## **REVISION RESPONSE LETTER**

**RE: UTE PASS RENTAL, INC**  
**Site Development Plan**  
**File Number PPR-18-028**

**DATE:** September 11, 2018

1 of 5
SITE PLAN

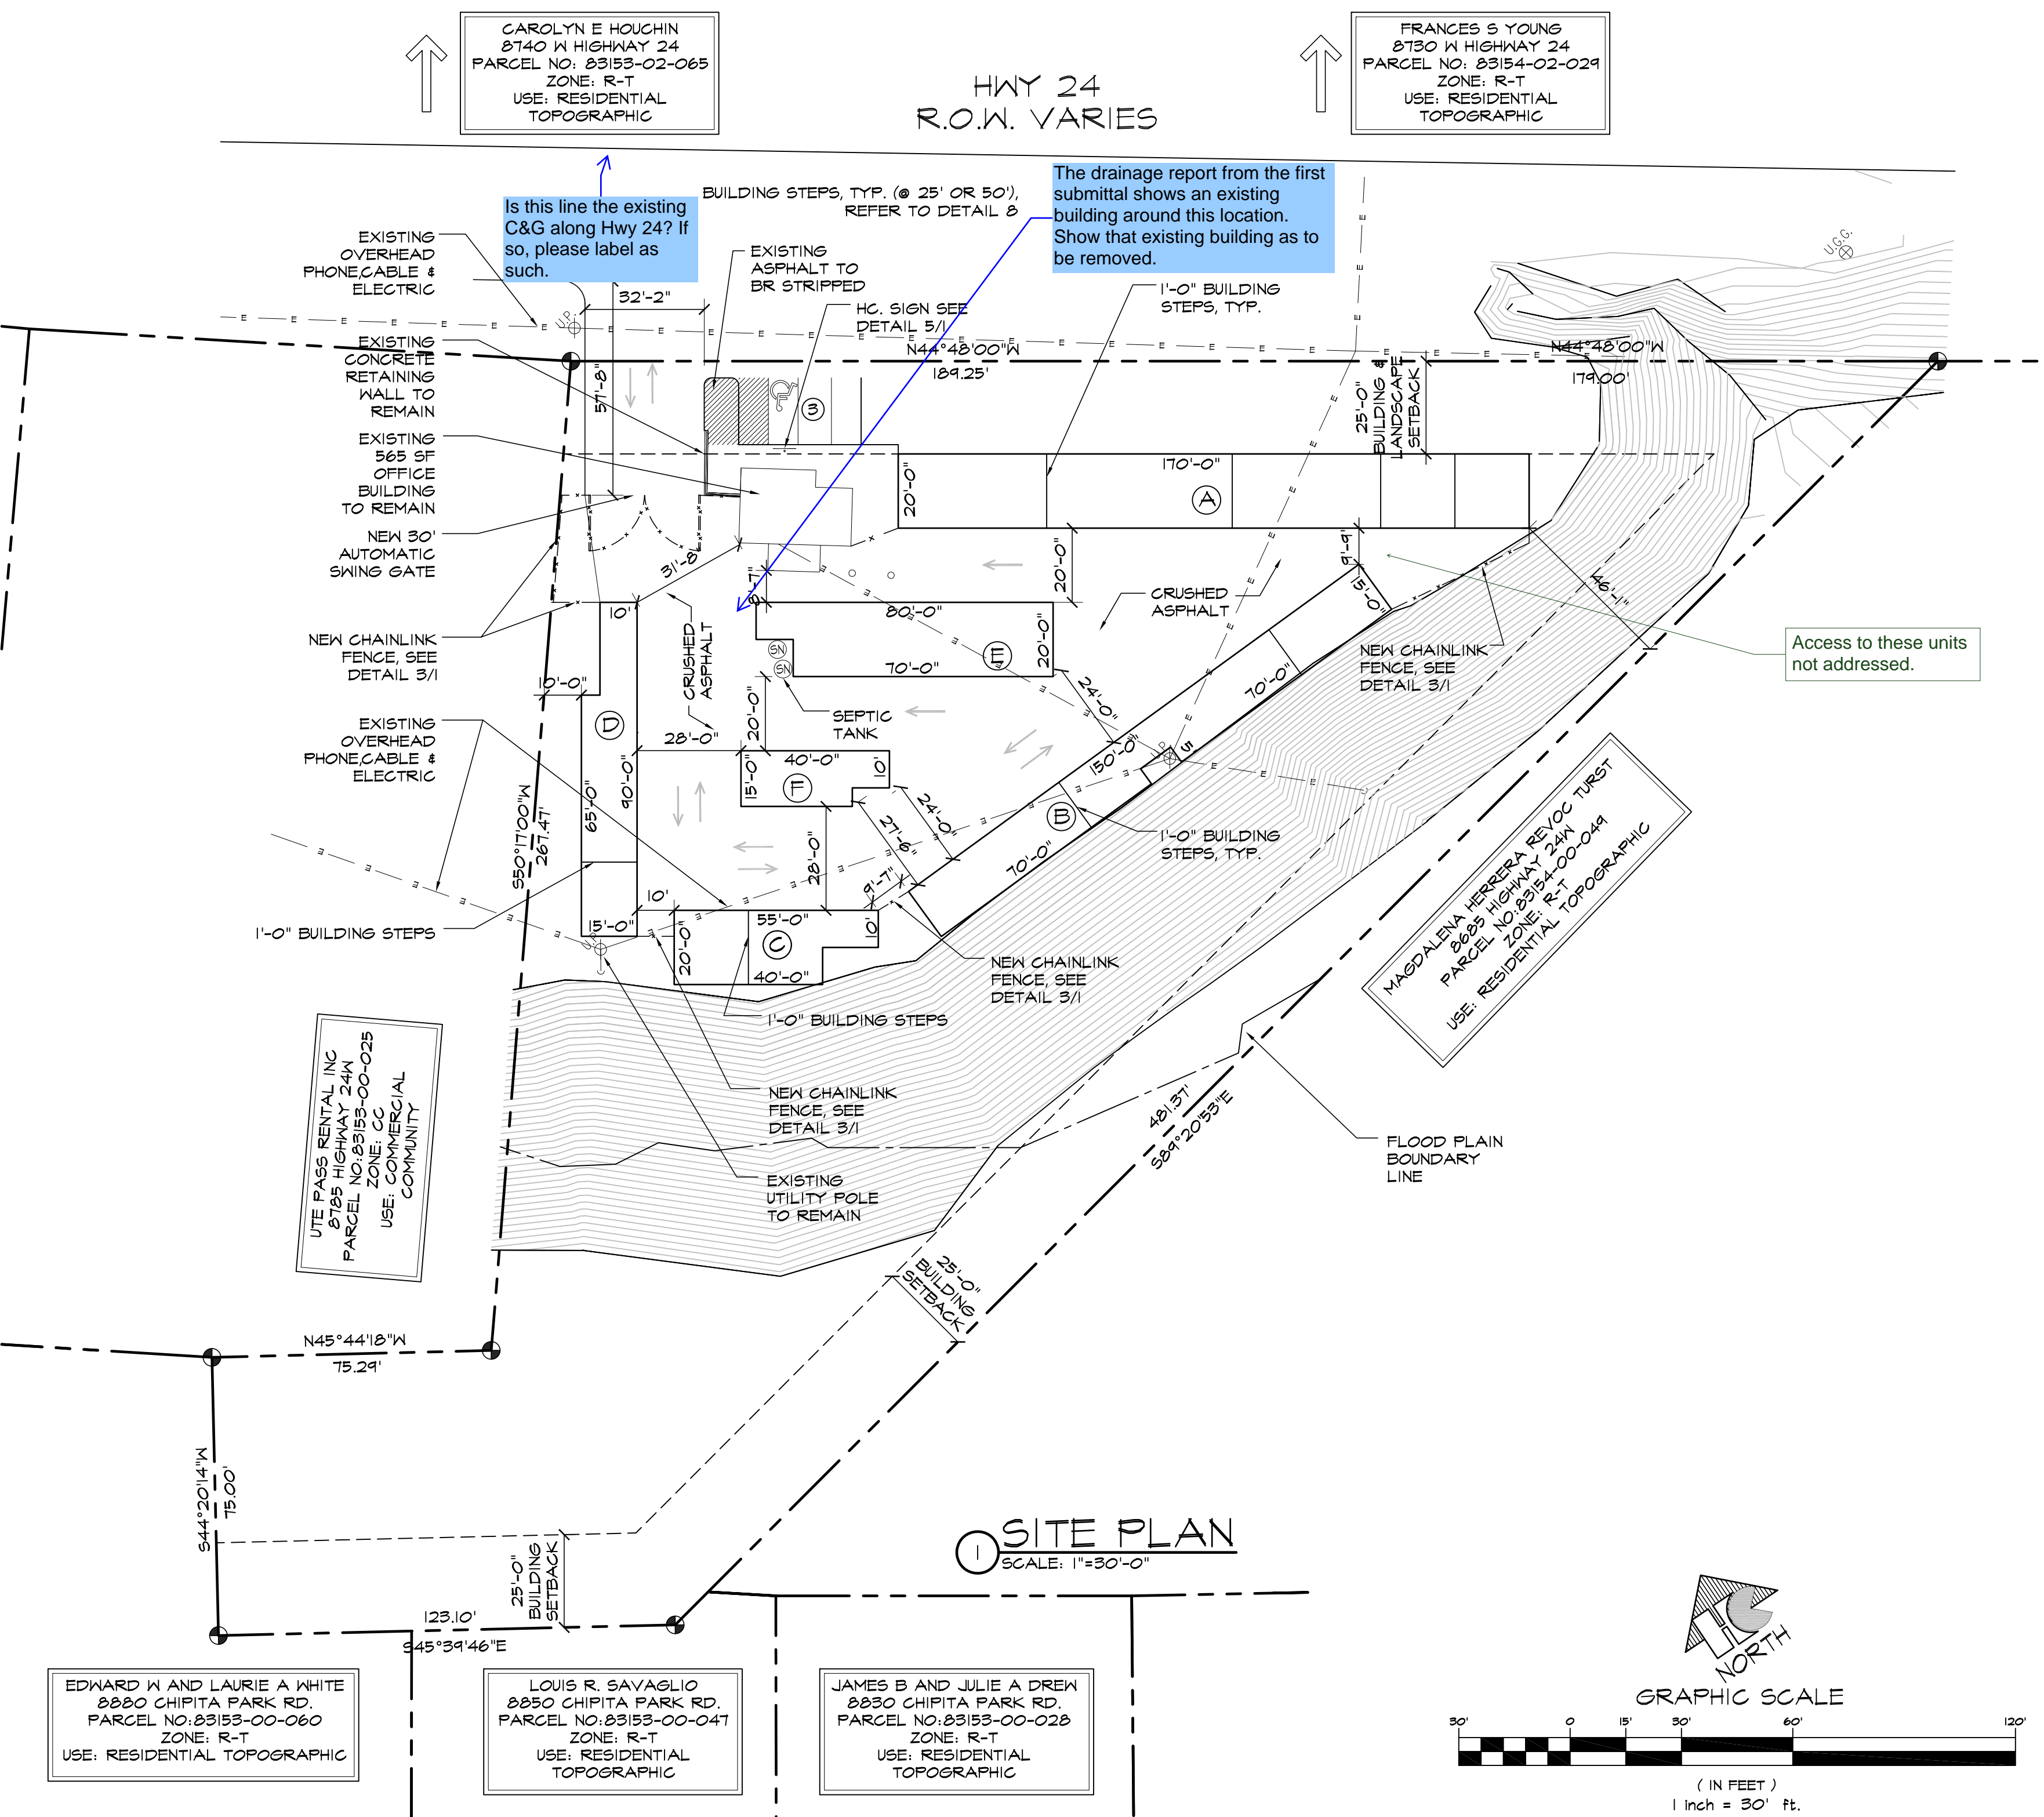
This does not accommodate the access issue on the SDP

If trash can be generated on the site, a trash enclosure must be provided

- **All storage bays are individuals. There is plenty of staging area to accommodate the access and maneuvering of storage items (boxes, furniture, etc.). In addition, the owners will provide carts to the clients for better ease of moving their belongings.**

- **The ADA note has been added.**
  - **There will be no trash enclosure on the site.**
  - **The parking area is the only proposed area to be paved. This area is currently existing asphalt and will just need to be restriped as shown on plans.**

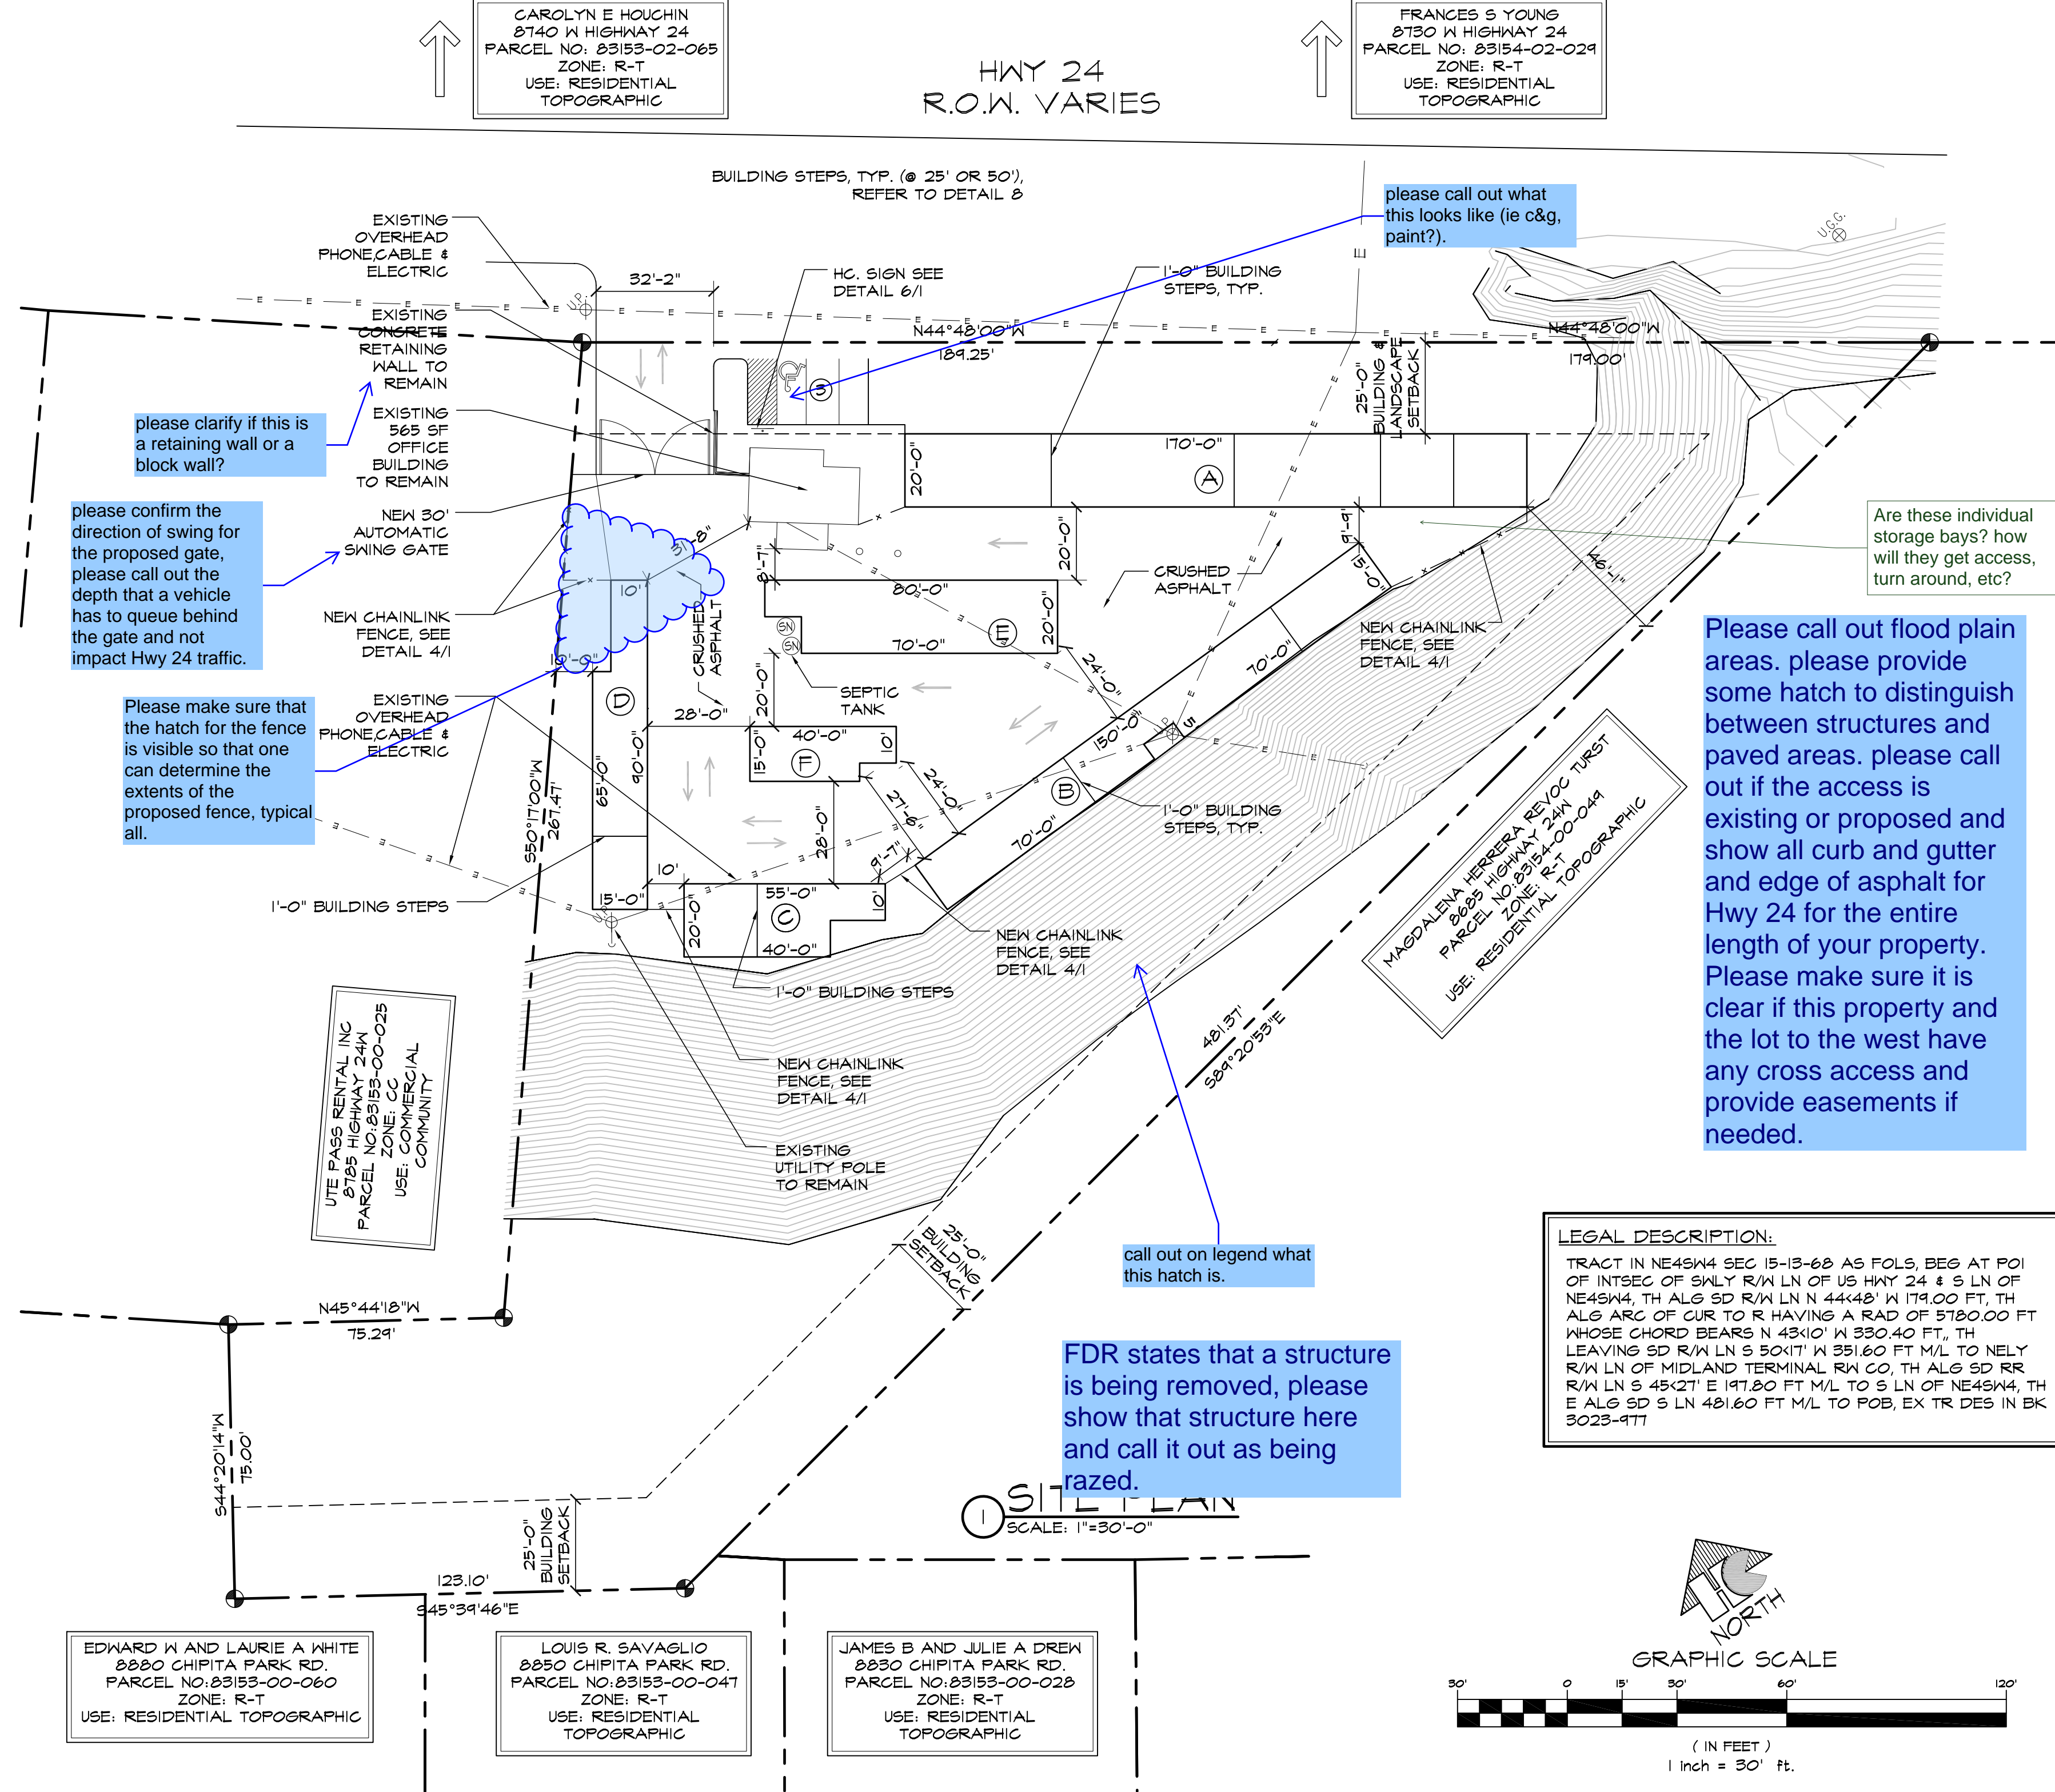
- *See Redlines*
  - **The retaining wall is an existing solid concrete wall, it is not a block wall.**
  - **The swing of the gate has been mirrored and a dimension has been added to show vehicle queue depth. This allows for 3 cars to be queued outside the gate. We don't anticipate this many to queue at all since it is an automatic gate, therefore this will not affect traffic on the Highway 24 frontage road.**

- **The fence hatch has been adjusted so the one can determine the extent of the proposed fence.**
  - **Grade line hatch has been added to the site legend.**
